From: Parish Clerk Billington and Langho Parish Council
<parishclerk@billingtonlanghopc.org>
Sent: 07 July 2026 16:56
To: Planning
Subject: 3/2026/0446

Following the meeting of the parish council the following objections and concerns are sent regarding this application.

Proposed Site Plan - Positions for lodges 1-9

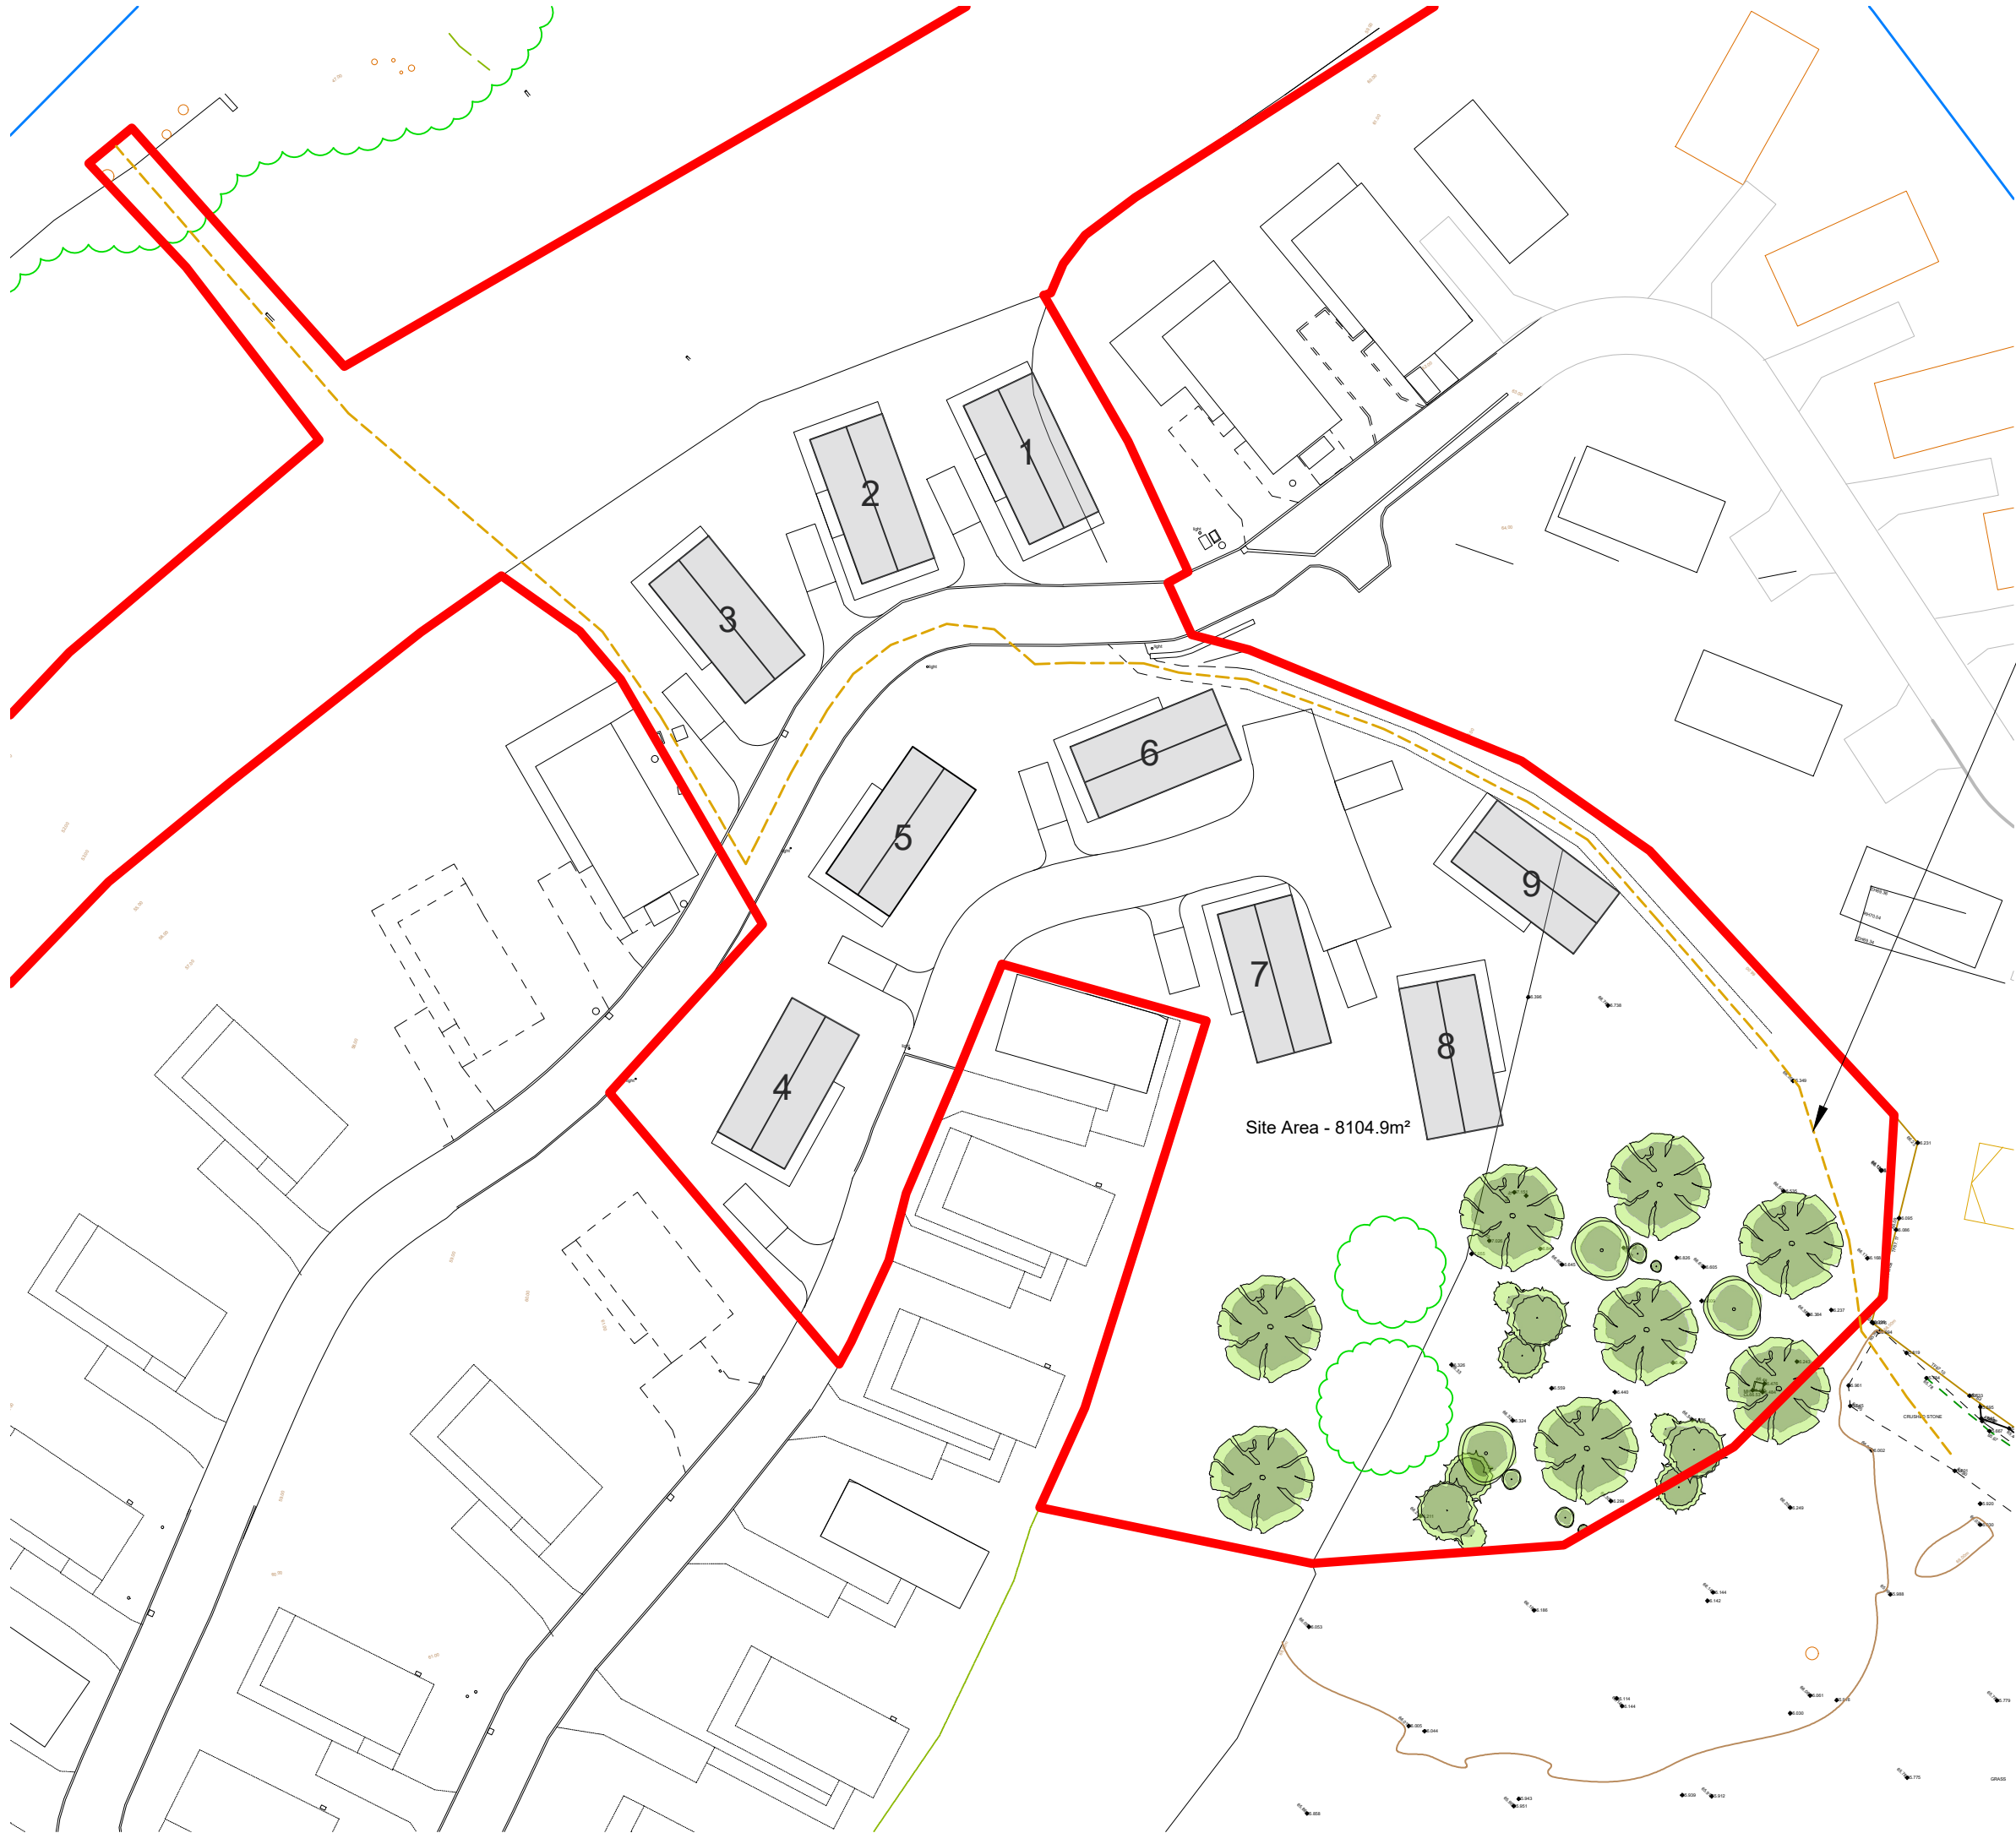
- The redirection of an historic footpath.
- This site has become as large as a village and generates a lot of traffic so we object to the Increase in traffic
- The loss of grass land and the over development in open countryside,
- The lack of control of the non residential aspect of the site
